Appeal Decision

Appeal Ref: APP/R5510/W/25/3370257

11-17 Victoria Road, Ruislip, HA4 9AA

- The appeal is made under section 78 of the Town and Country Planning Act 1990 (as amended) against a refusal to grant planning permission.
- The appeal is made by Perl Equity (Ruislip) 4 Limited against the decision of the Council of the London Borough of Hillingdon.
- The application reference is 72104/APP/2025/1096.
- The development proposed is erection of ground floor rear extension and three-storey extension (with top floor set-in) above existing commercial parade to provide 7 residential units (2 x 1 bed, 2 person units, 4 x 2 bed, 3 person units and 1 x 3 bed, 5 person unit).

Proposed Front Elevation
Scale 1:100

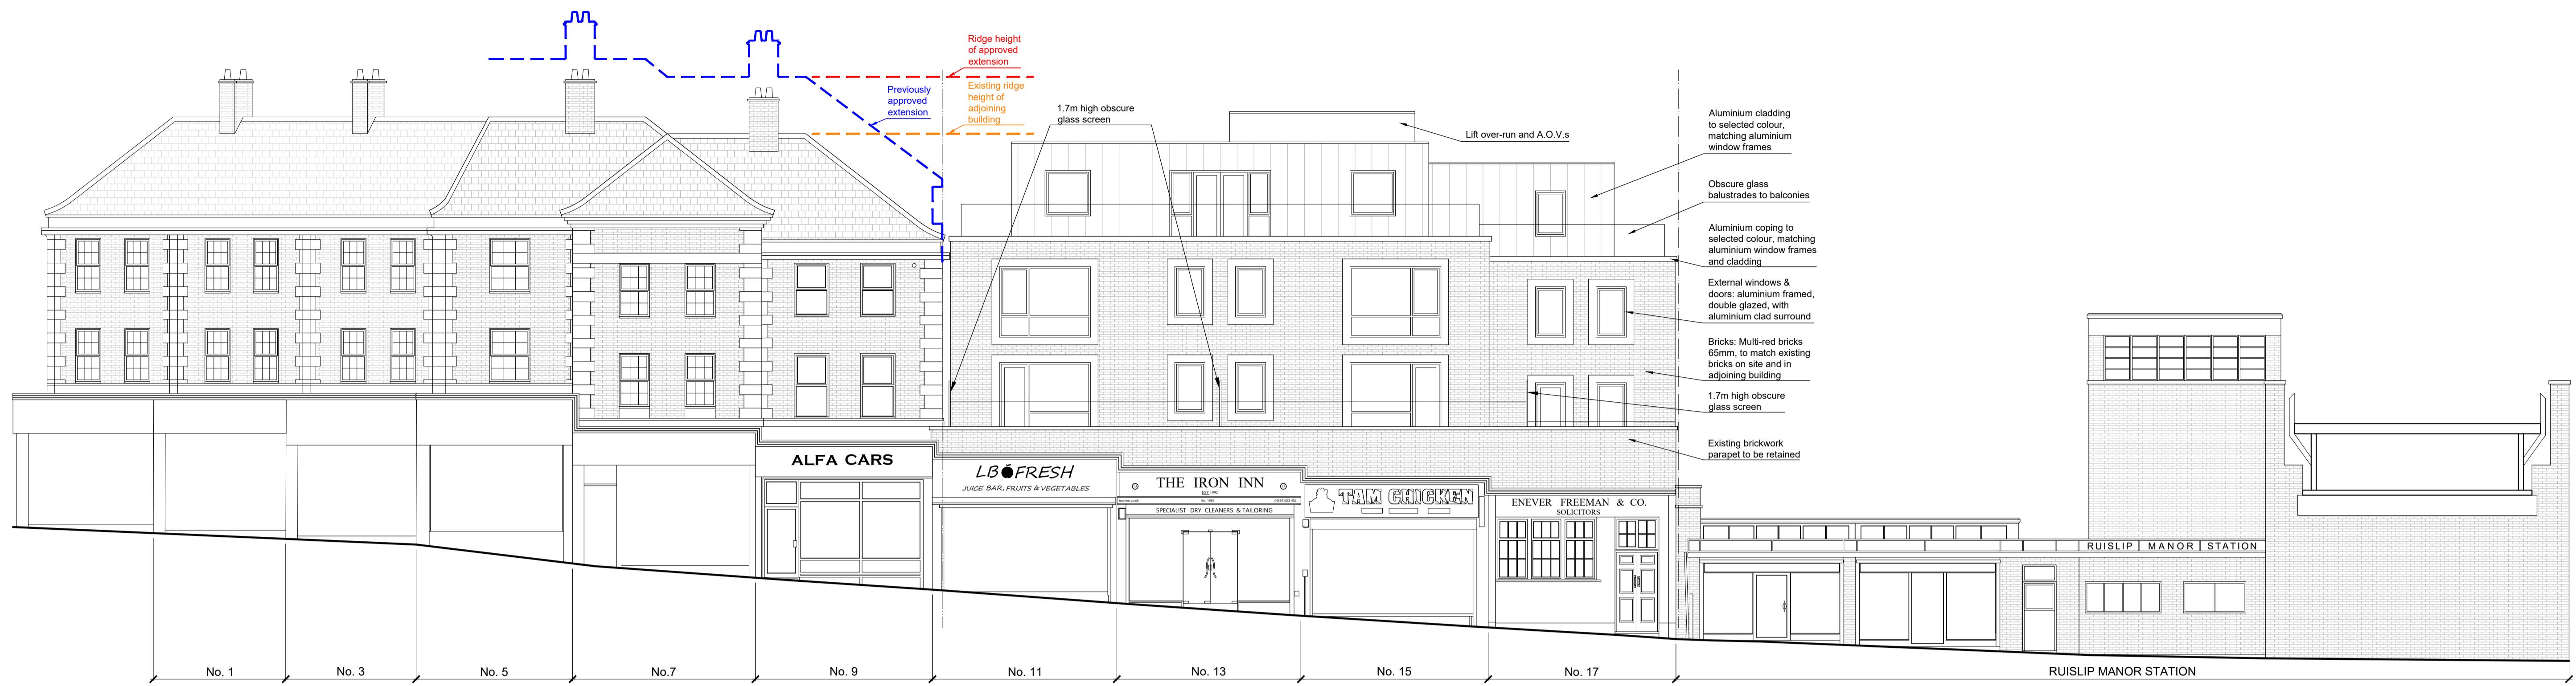
7. However, the adjacent terrace has a strong, vertical emphasis accentuated using stone quoins and a repeating pattern of tall narrow windows set close together. By contrast, the front elevation of the proposed development would feature several wide windows interspersed by smaller openings set within sizeable expanses of solid brick wall. This fenestration pattern and solid-void ratio would create a jarring horizontal emphasis out of keeping with the architectural rhythm and balance of the neighbouring building.

Proposed Ground Floor Plan
Scale 1:100

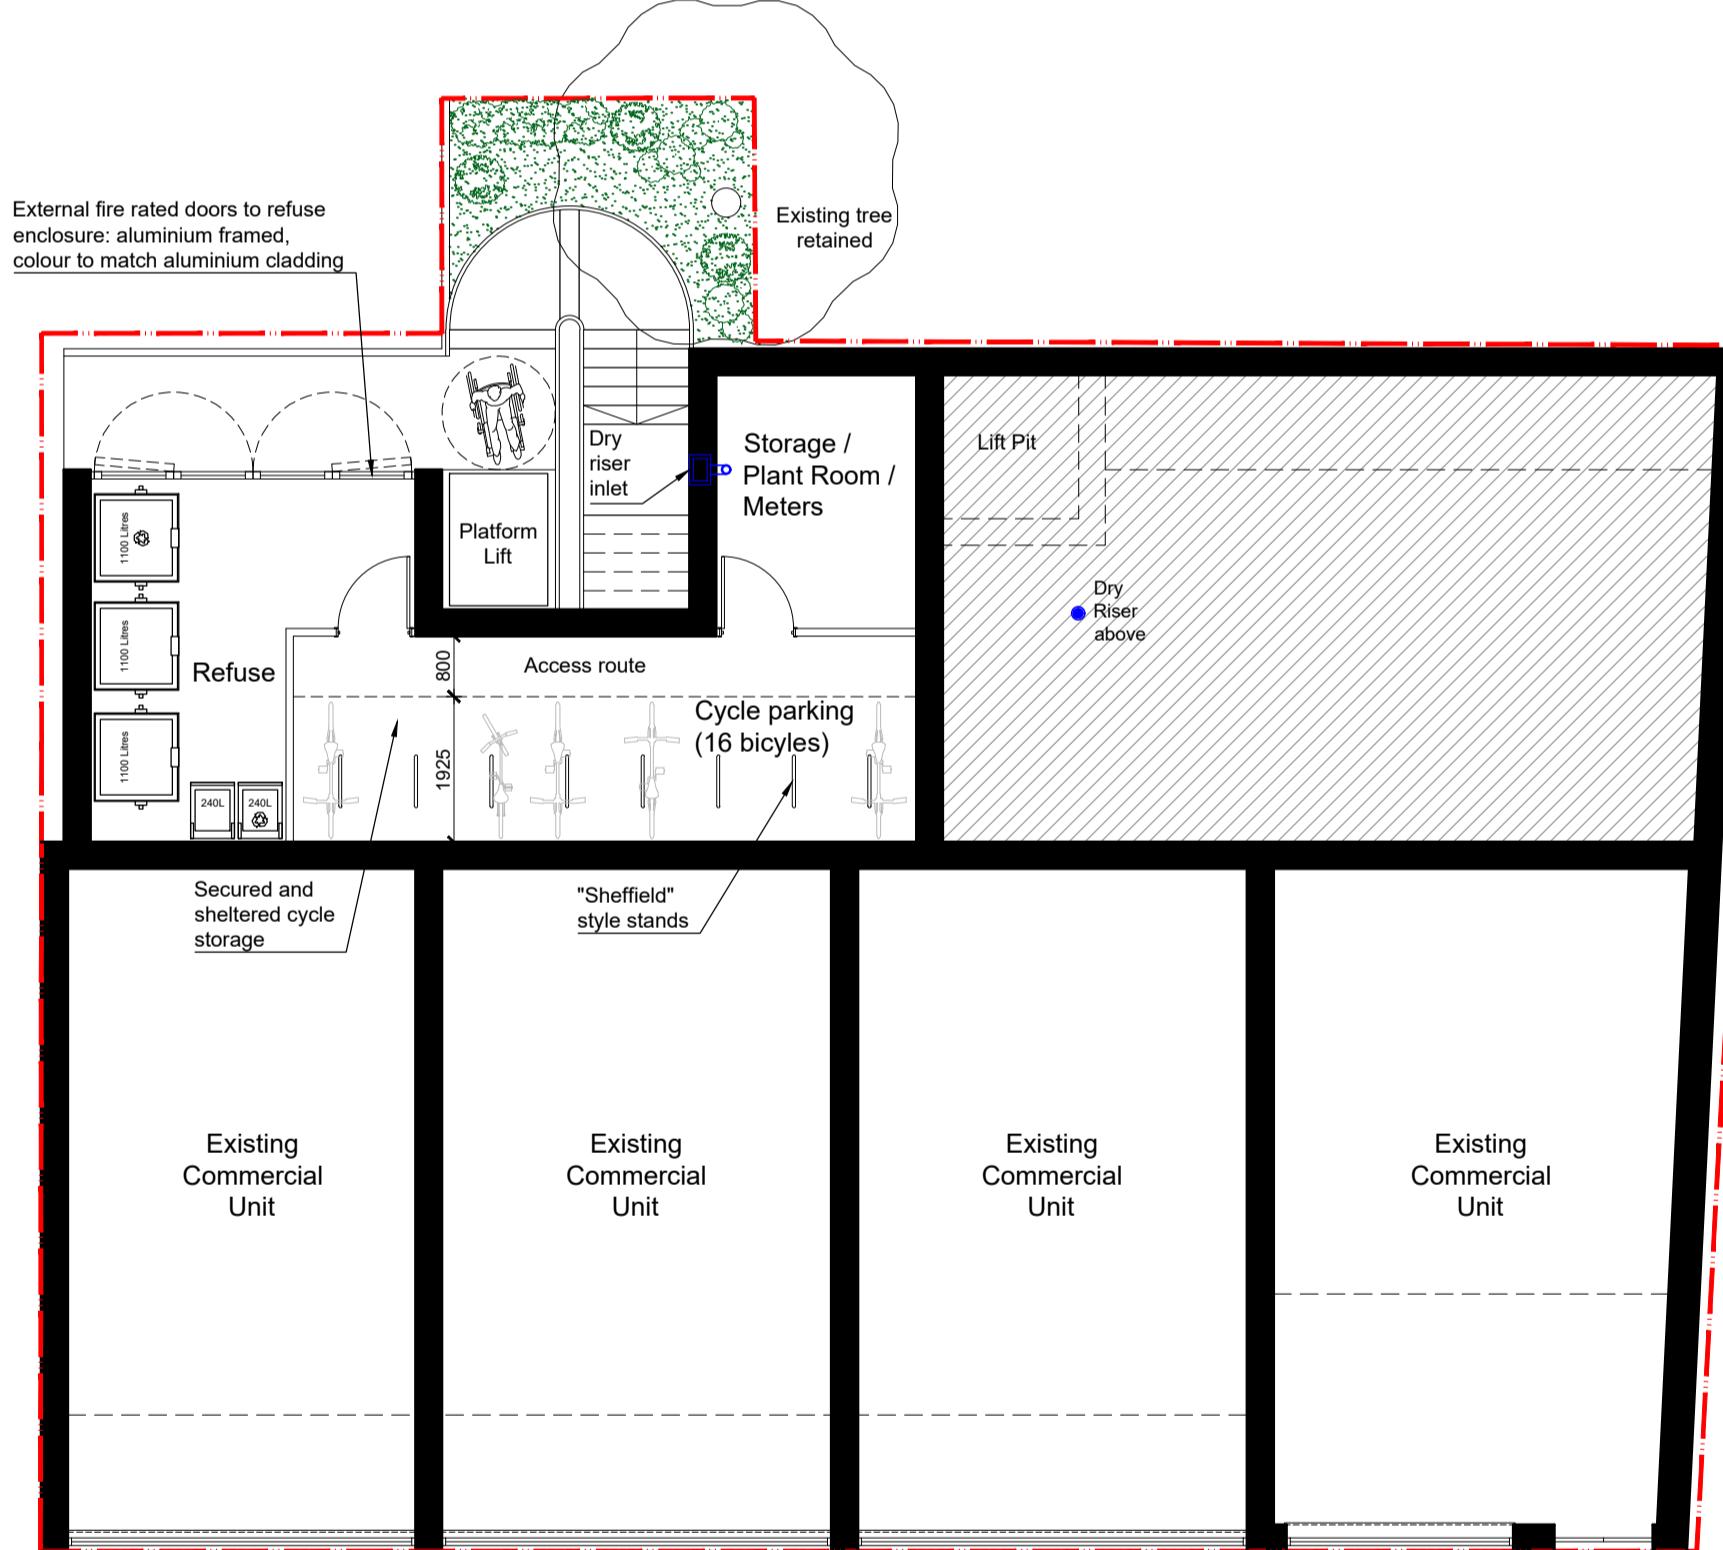
8. Turning to the matter of movement and safety, the sole pedestrian access to the proposed development would be via the rear shared service yard which does not benefit from delineated pedestrian routes or street lighting. Therefore, pedestrians using the space may come into conflict with vehicle movements and would be less visible, especially at night. The fact that the proposed access route is the same as that already utilised by the occupants of existing flats does not justify sanctioning an intensification of this unsatisfactory arrangement.

9. The door to the flats would be positioned in a blind corner of the yard, to the side of an existing block of outbuildings and largely screened from the rear windows of the existing and proposed flats due to the form and layout of the development. It would thus be secluded, with limited natural surveillance, creating opportunities for crime and anti-social behaviour. For these reasons, the appeal scheme would not provide a safe and secure environment for occupants and visitors.

Proposed Rear Elevation
Scale 1:100

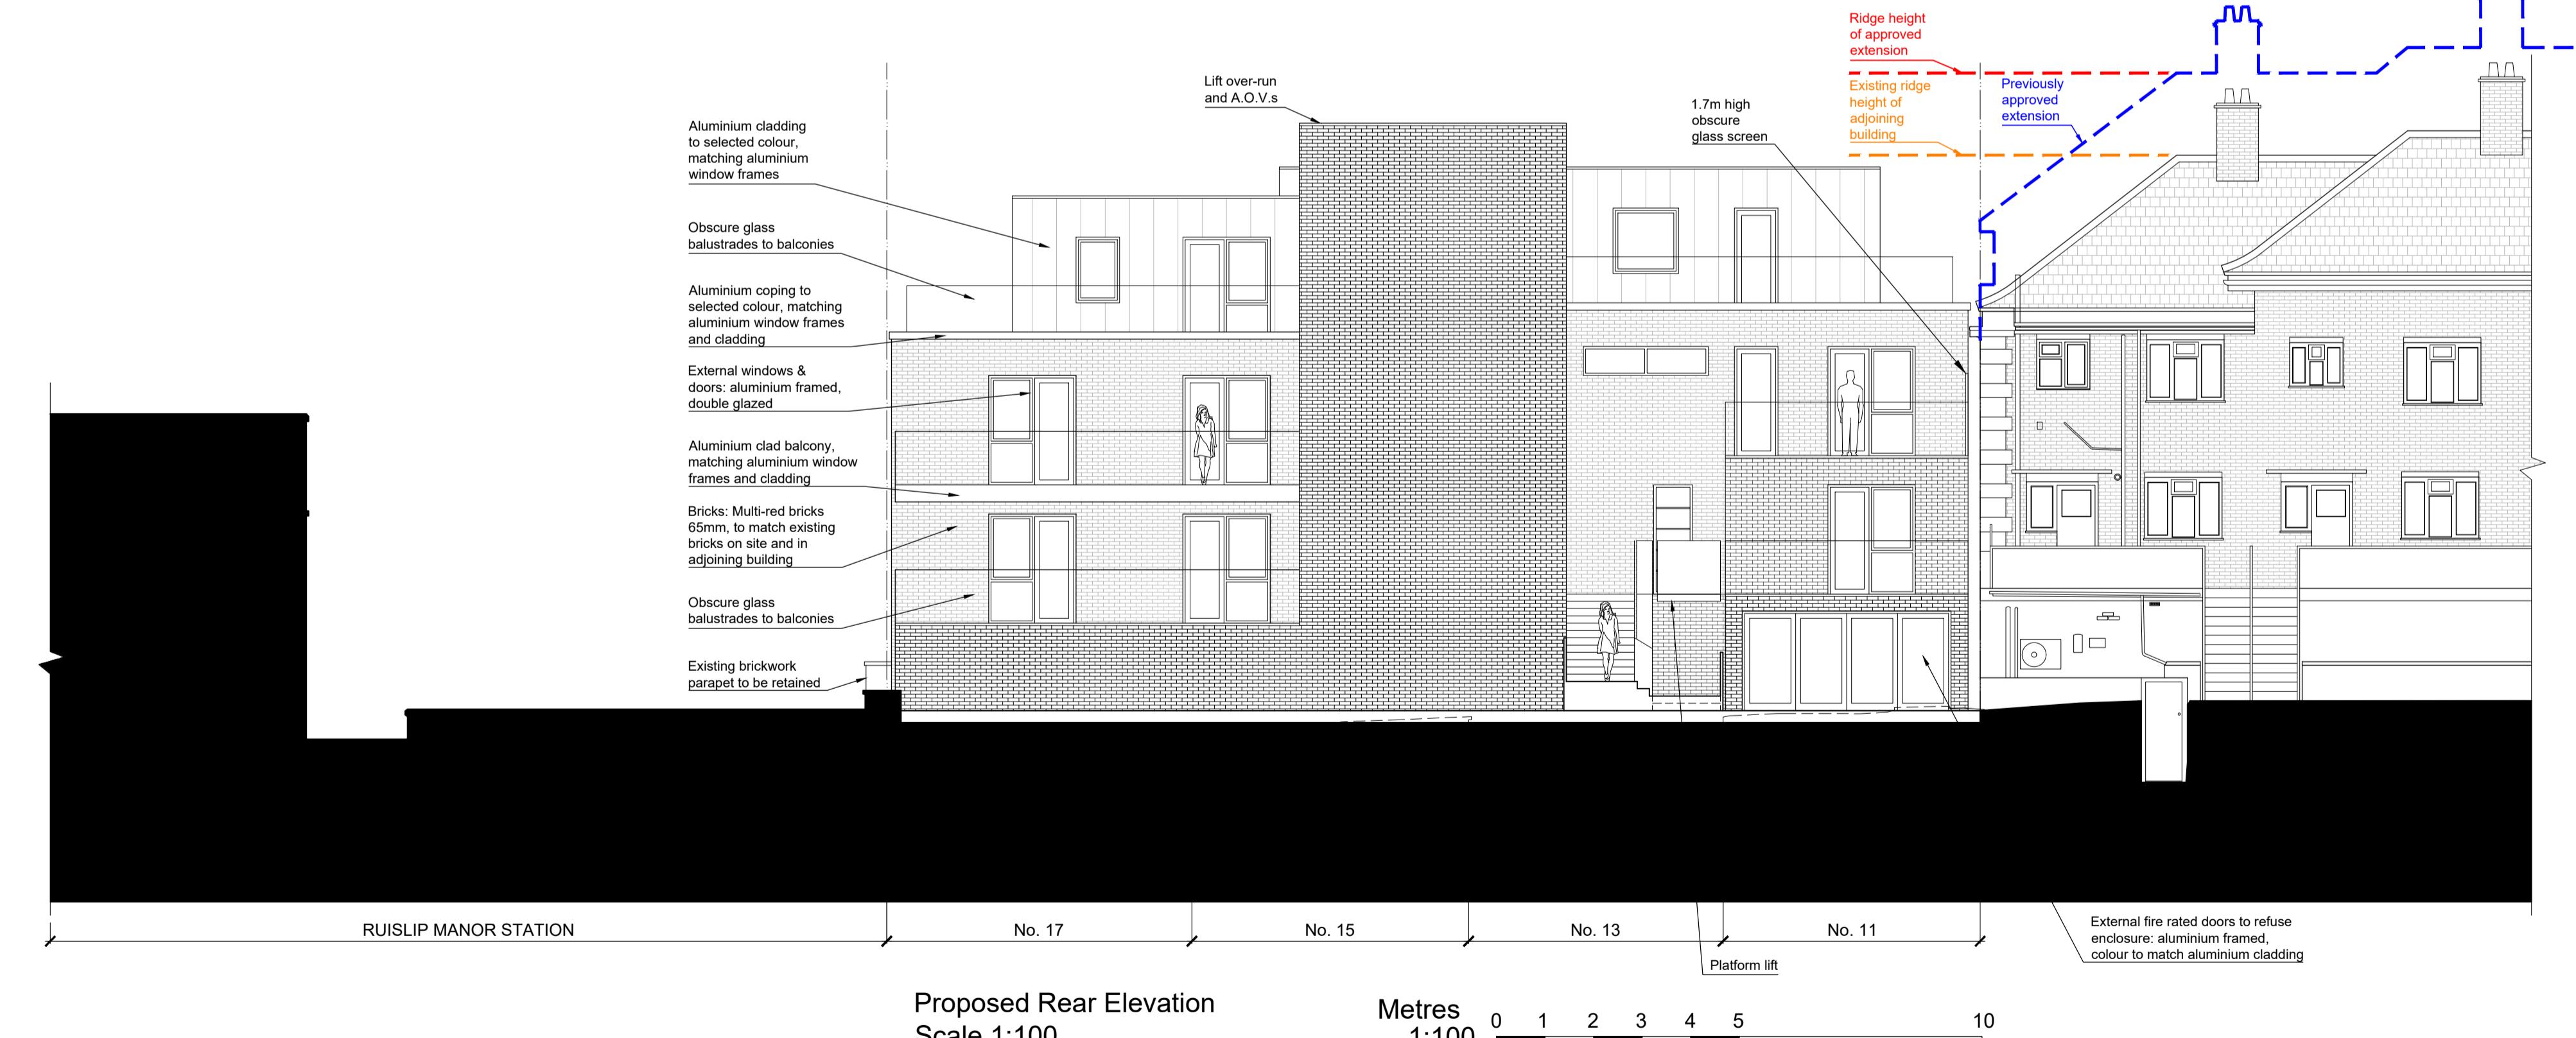
Main Issues
